Sizewell C Project: Proposed Two Village Bypass

Note on survey for dormouse *Muscardinus avellanarius*

Bioscan UK Ltd, on behalf of (Farnham Environment Residents & Neighbours) – 15 July 2021

Figure 1C - BAT CROSSING POINT SURVEY REPORT 2021 – Two Village Bypass Crossing Point Locations

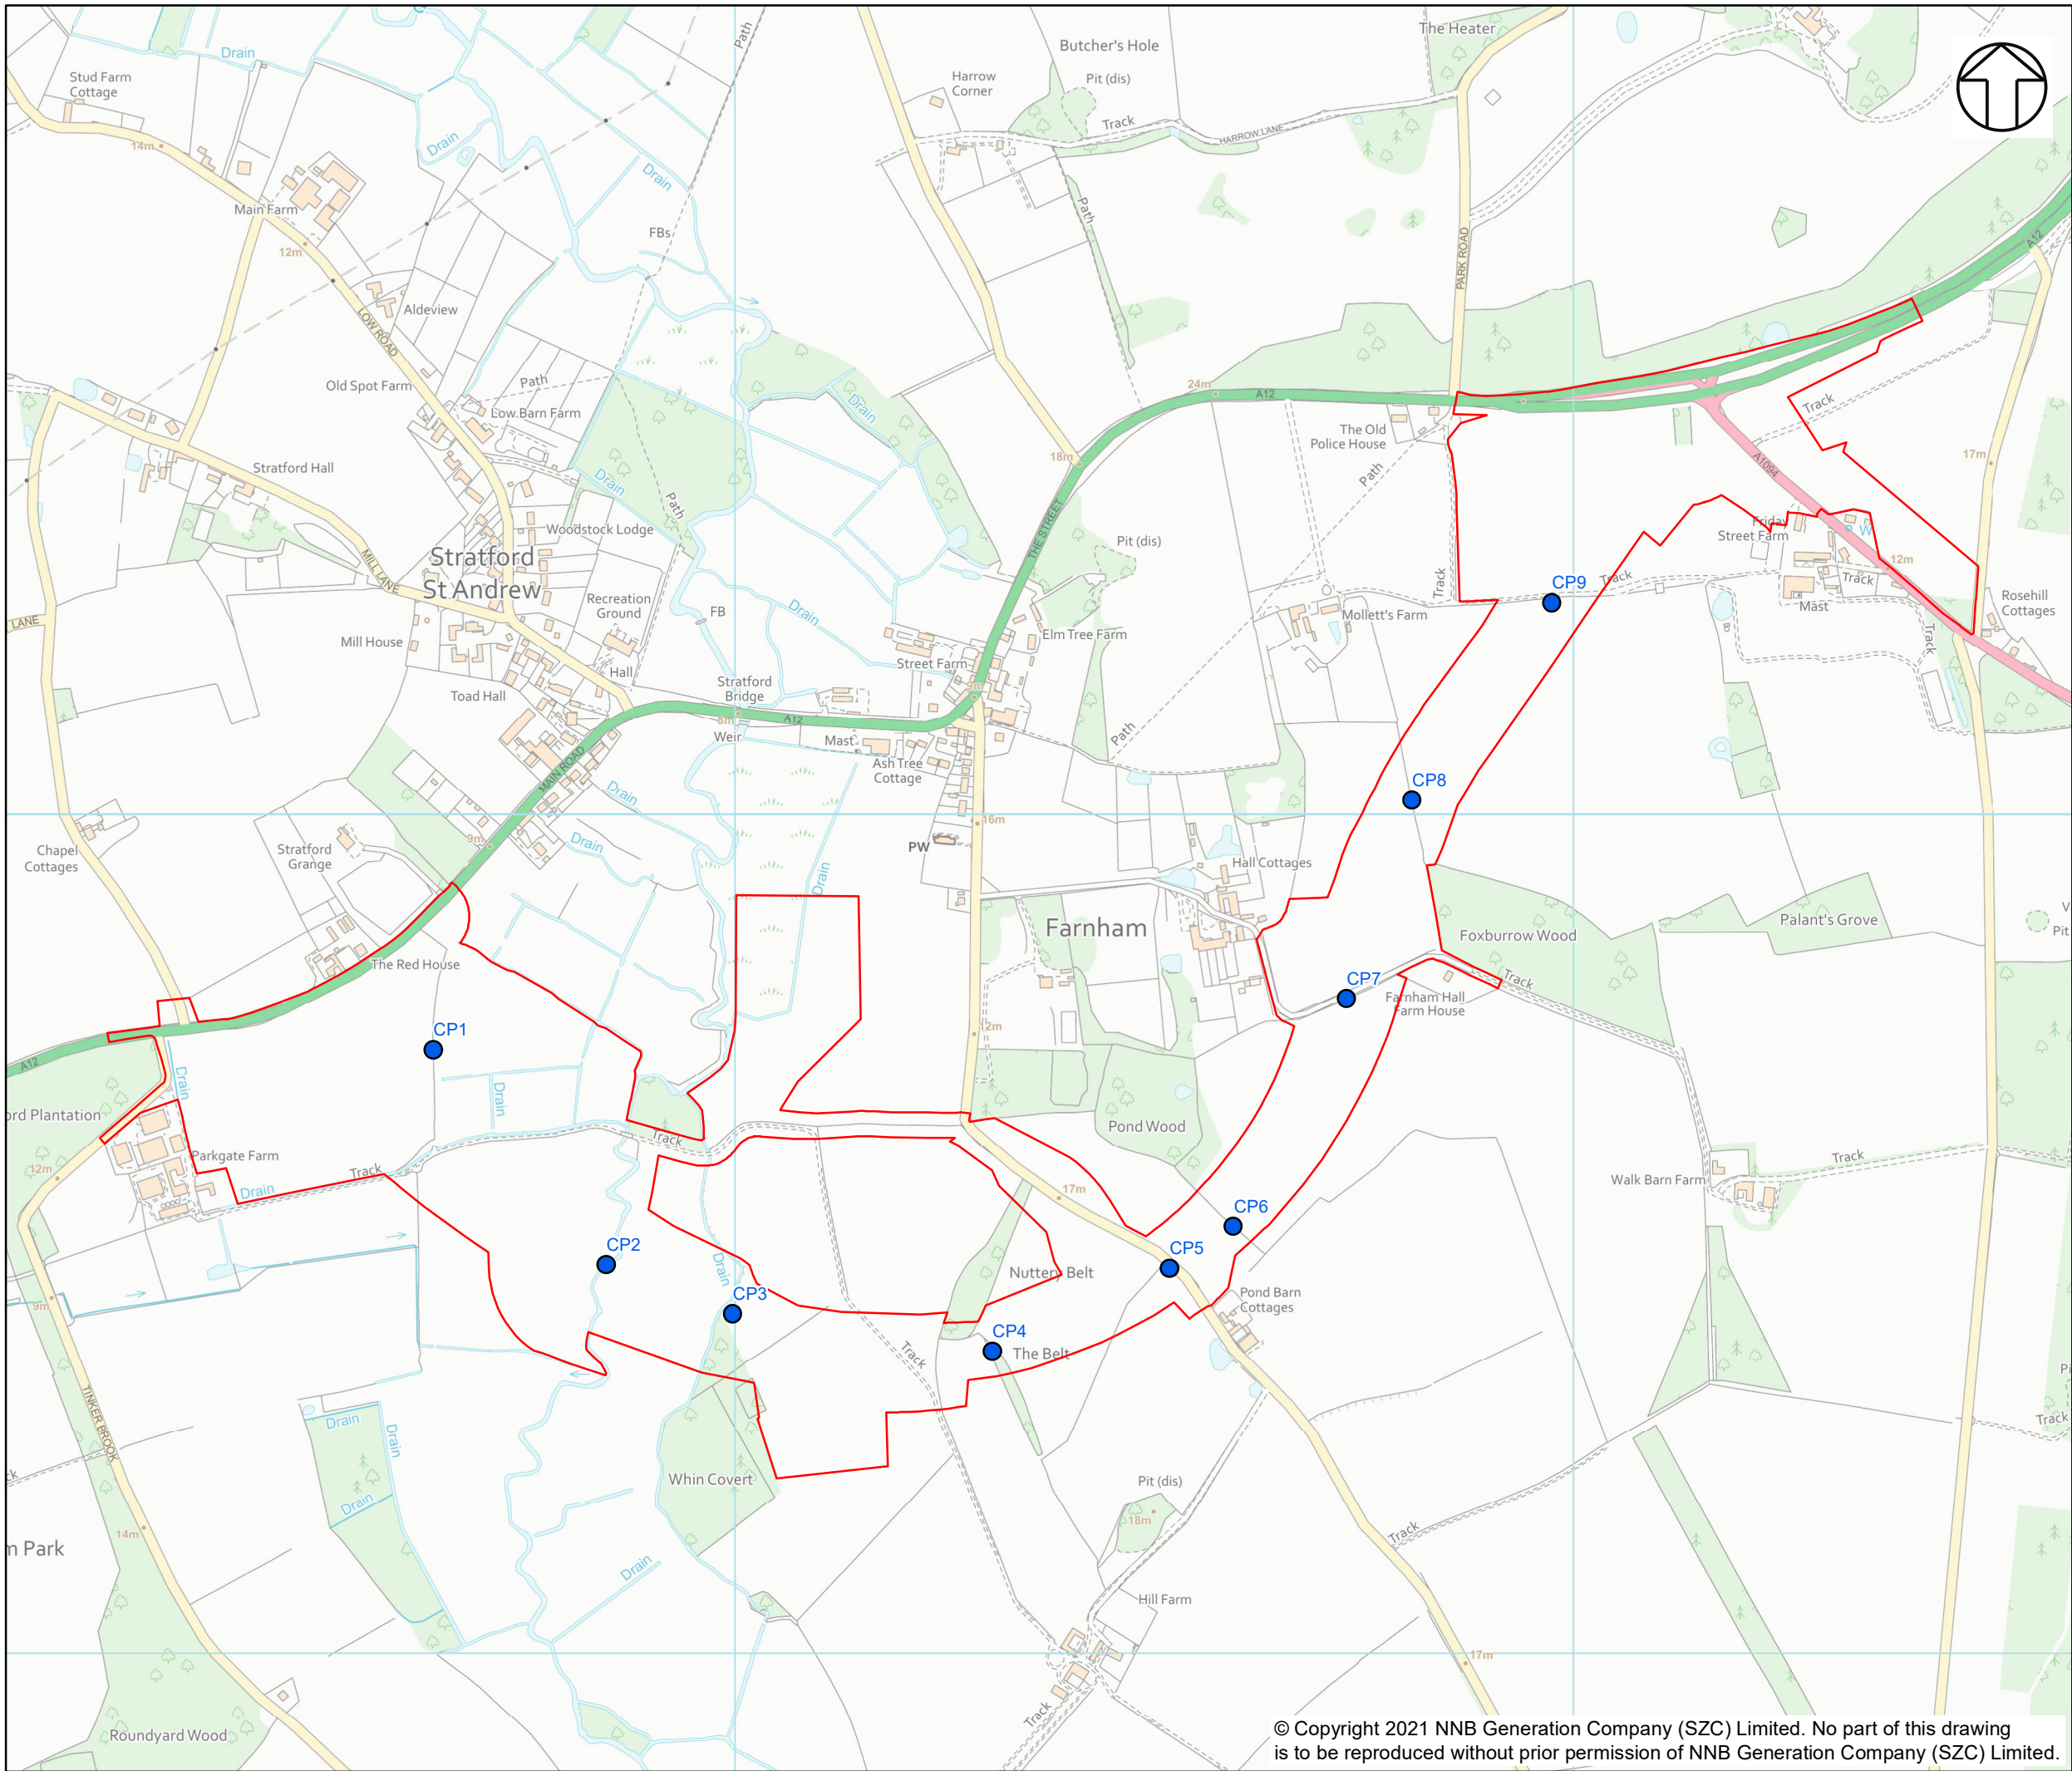
- Nest tubes to be installed at least double the required density, i.e. every 10m within hedgerows, woodland and scrub;
- Nest tubes to be supplemented by nest boxes at a ratio of 1 box :10 nest tubes (noting that NE's advice is that they increase the probability of finding dormice);
- Nest tubes and boxes to be installed in all suitable habitat. This includes not simply the woodlands as suggested during the hearing, but also the scrub and hedgerows (noting that it is often much easier to detect this species in dense hedgerows than in overstood woodlands).
- Given that the woodland is in many places overstood, alternative supplementary methods should be deployed in all woodlands and tall hedgerows within the Order Limits (e.g. including Nuttery Belt and the hedgerows along Farnham Hall lane: H22, H23, H24), including deployment of footprint tunnels² and camera traps.
